Planning Application Ref: FP/203/17/PL (2)

Location : 7 Middleton Road, Felpham

Description of works: Demolition of outbuildings & erection of 1 No dwelling to the rear [resubmission after FP/137/17/PL].

GROUND PROTECTION MATTING ZONE

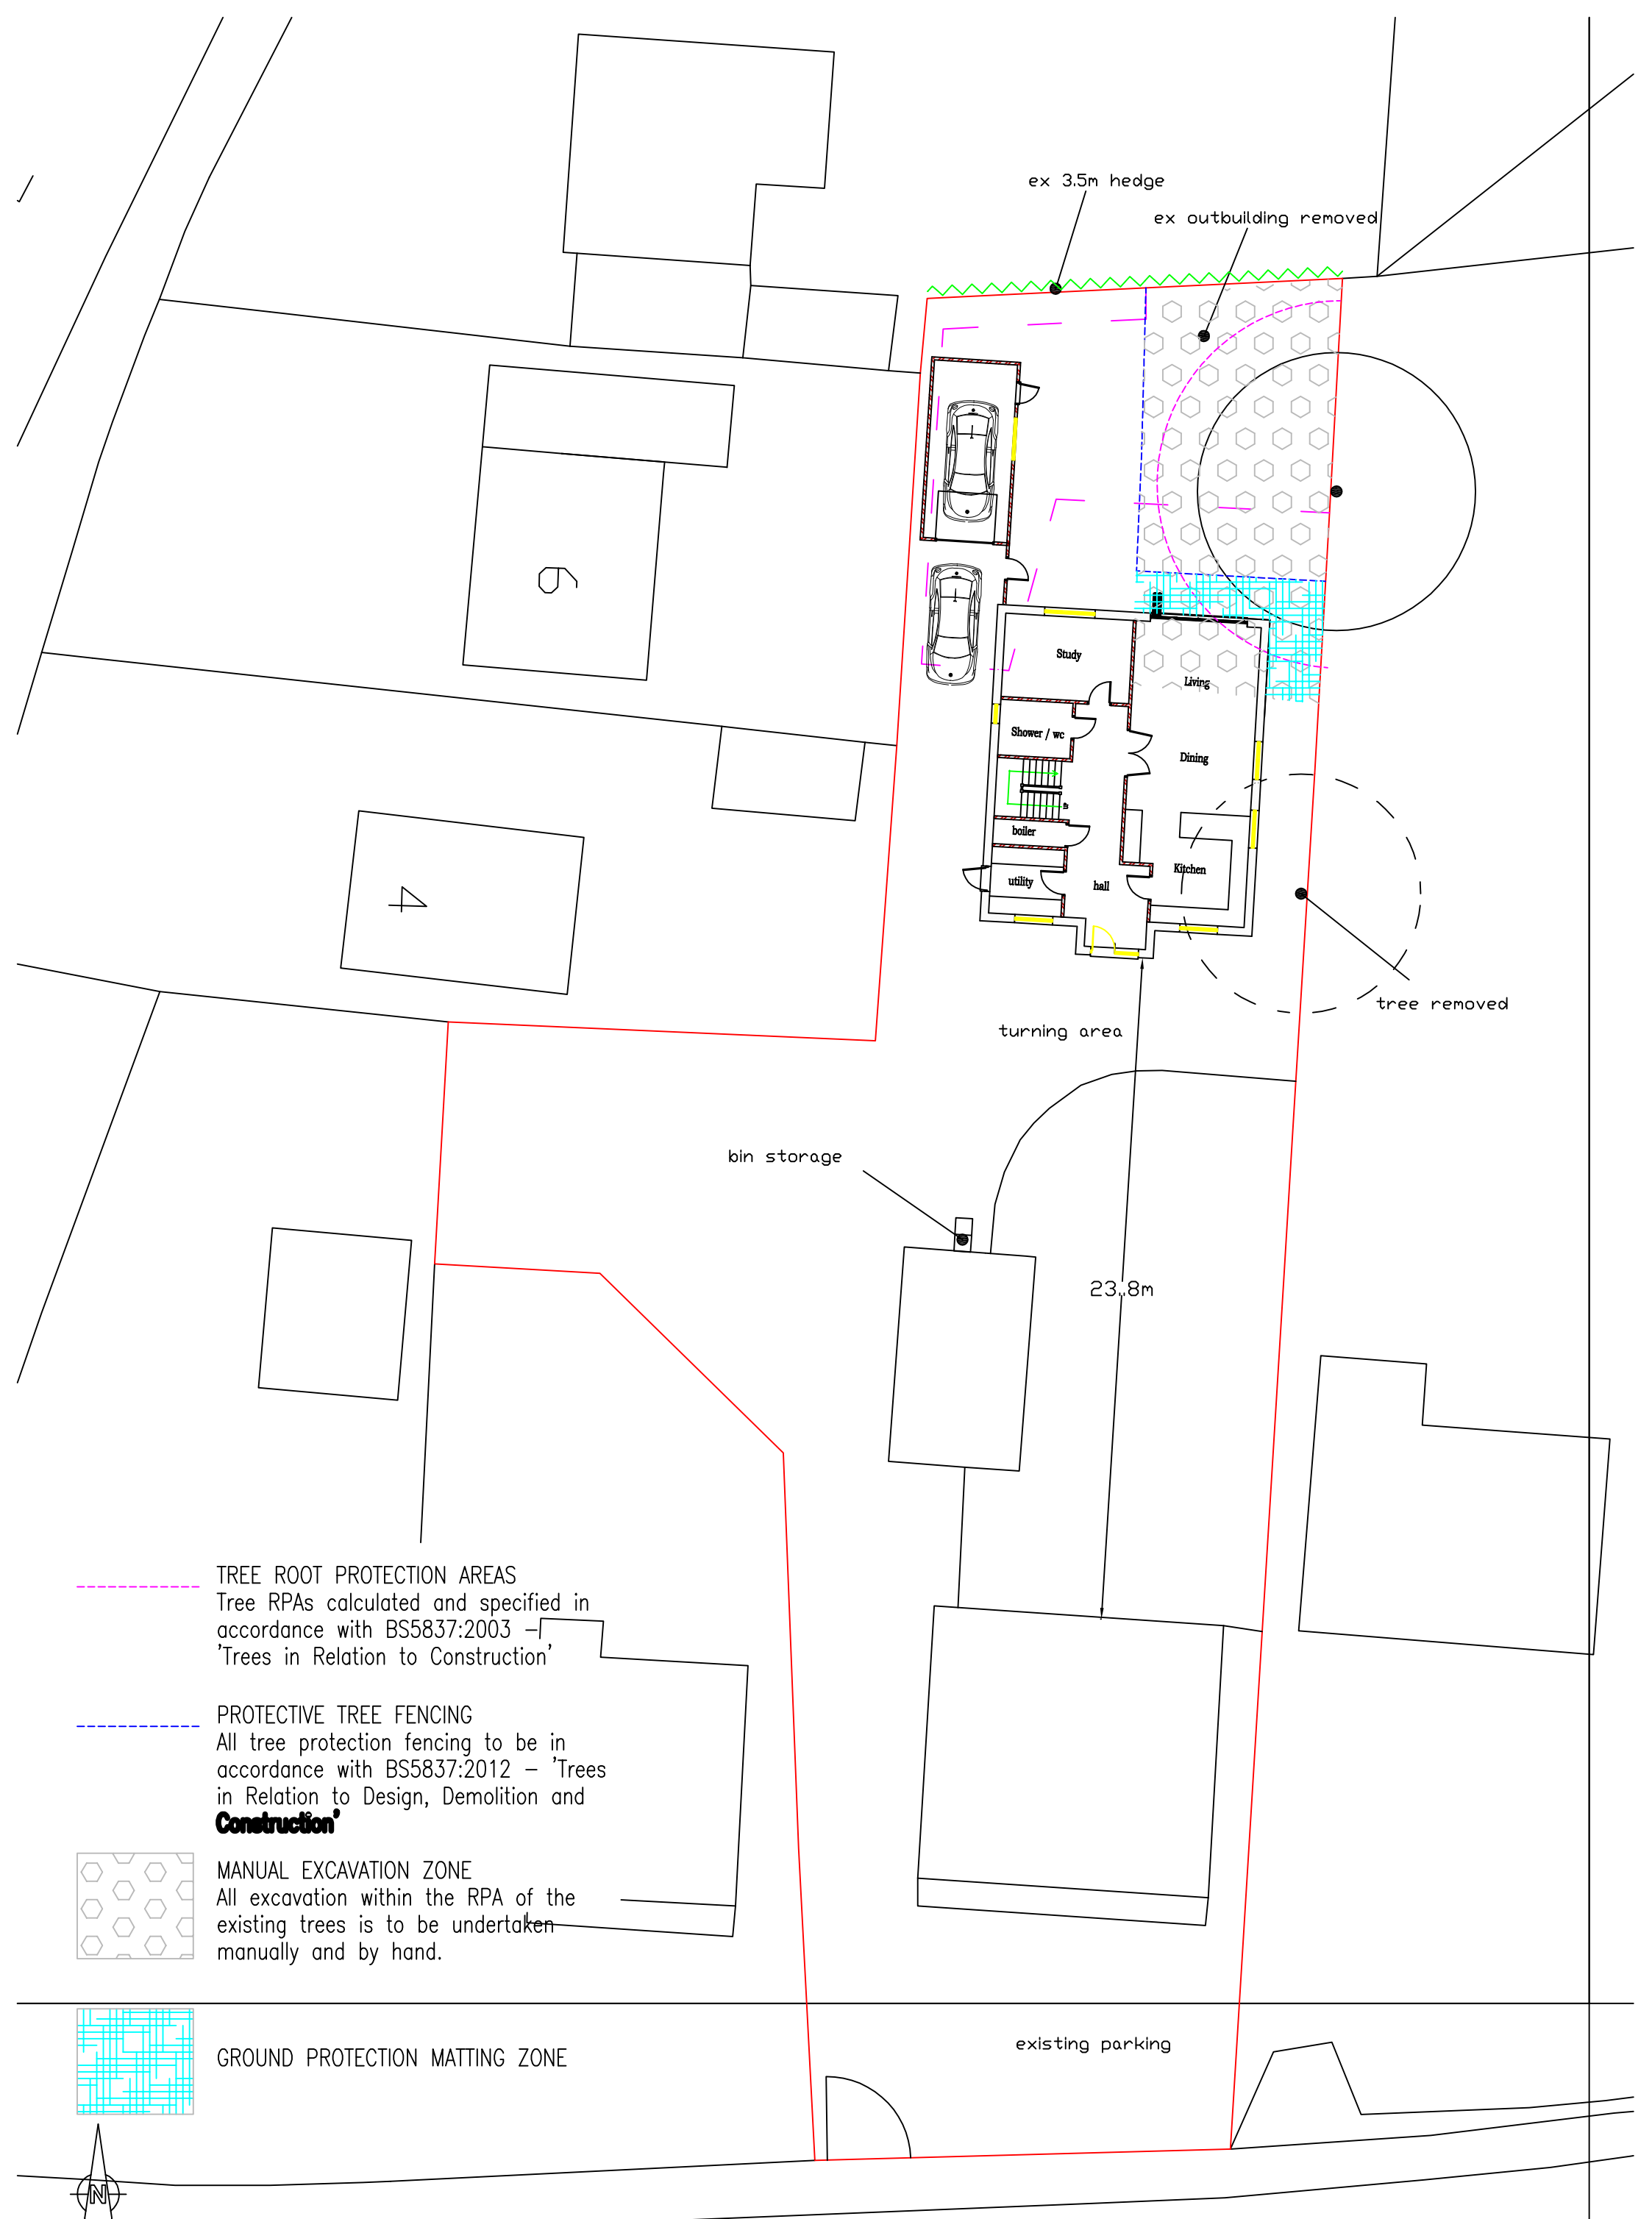
- There are off-site trees immediately adjacent to the zone to be demolished and a new building erected thus the applicant was asked to submit further information prepared by an Arboricultural Expert.
- Amended details have now been provided by Stephen Jupp (Planning Consultant) along with an amended Tree Protection Plan.

- The applicants Planning Consultants report has grasped the main gist of the issues in that phased demolition is advised and then erect protective fencing immediately that open ground is exposed beneath the existing structure.
- The protective fencing has at my suggestion now been set back from the main building line to provide for scaffolding and pedestrian access to facilitate the build.
- In addition to this appropriate Ground Protection measures have been specified for the intervening space onto which the scaffolding will be erected.

- My concerns have all been answered and I withdraw my objection to the scheme and now recommend **APPROVAL** for same subject to the following planning condition being applied:-

*All demolition & construction works are to be carried out in strict accordance with :- **Arboricultural Impact Assessment Report Ref: Stephen Jupp - September 2017 and Tree Protection Plan ref: Drawing 7D-1:200 @ A3.***
